In relation to the above site addresses Full Planning Application, seeking approval for a new first floor flat above the existing ground floor office and following receipt of your previous email, please find attached a series of revised drawings which remove the previously proposed half hip ending for the extended section of roof.

'The applicant has not provided any details of any assessment undertaken with regard to potential odour nuisance from the Pad Thai restaurant next door impacting on future residents. Please could this be provided in order that Environmental Health may assess any potential odour impact.'

PROPOSED SITE ROOF PLAN

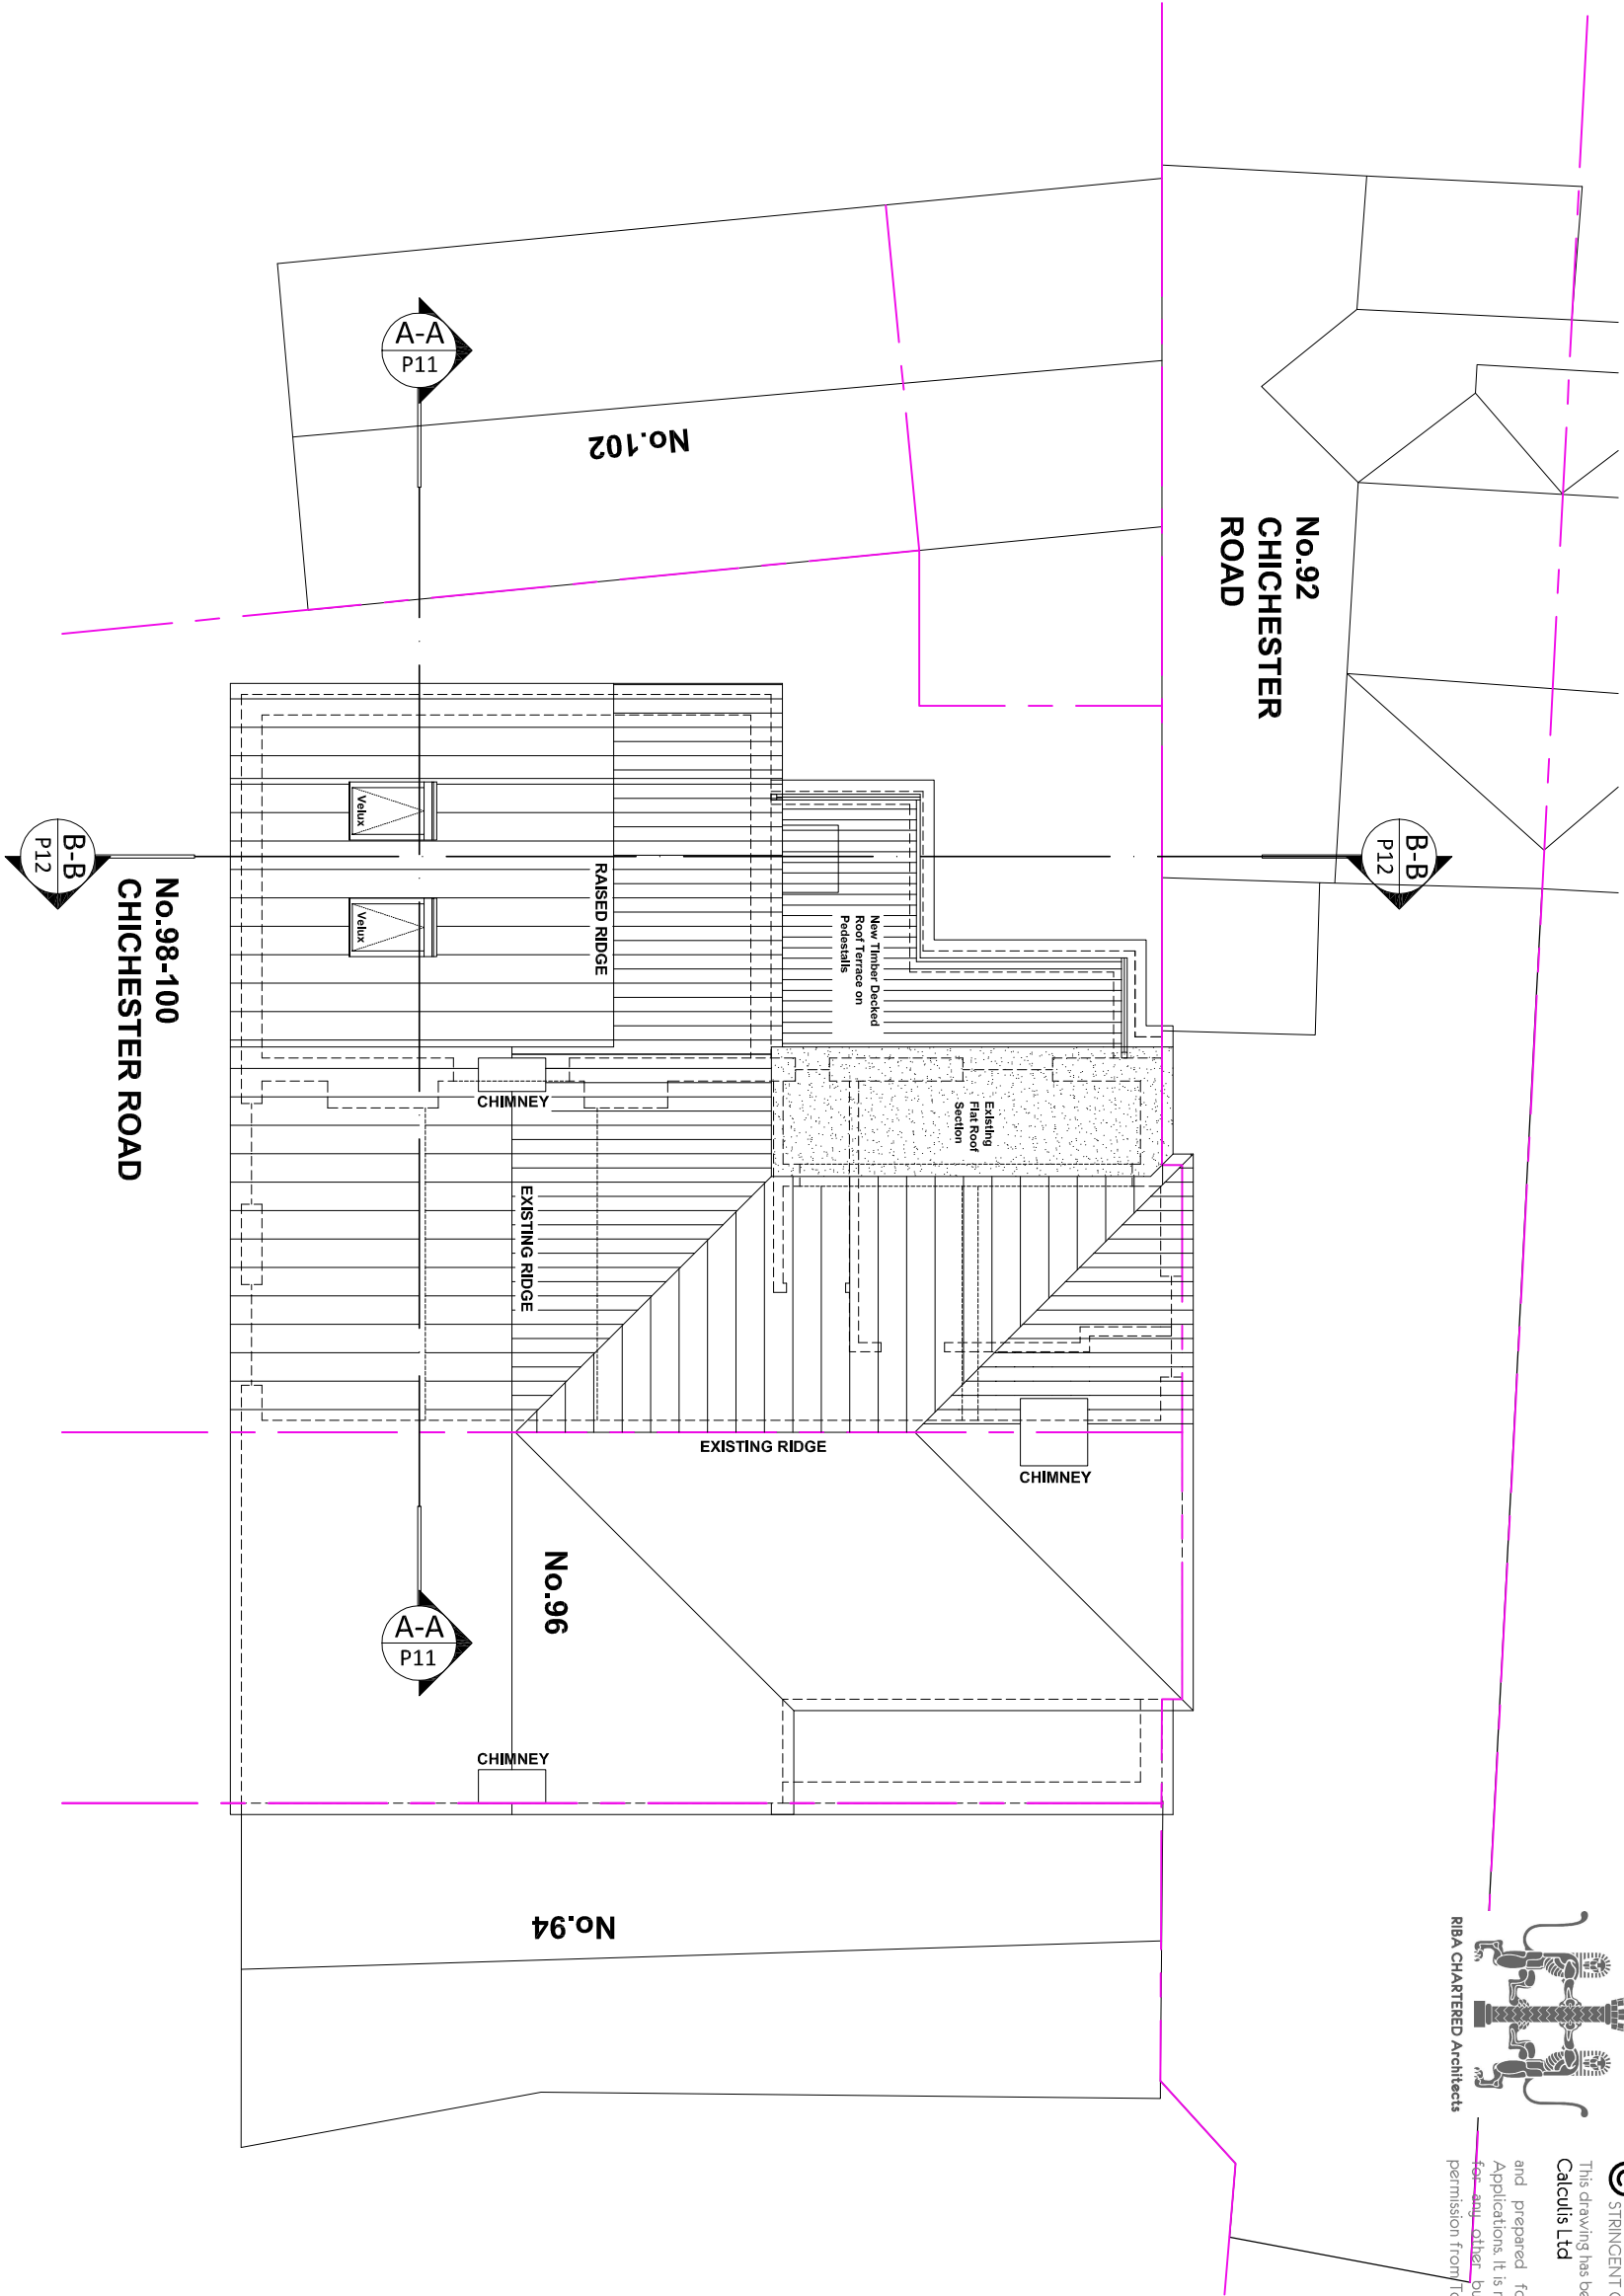
As a planning officer of this case I would like to advise you to change the proposed half-hipped ending of the extended roof to the gabled. I do understand your intension, however in this case it is unnecessary to copy what is to the right since the proposal property is a part of terrace with gabled ending.
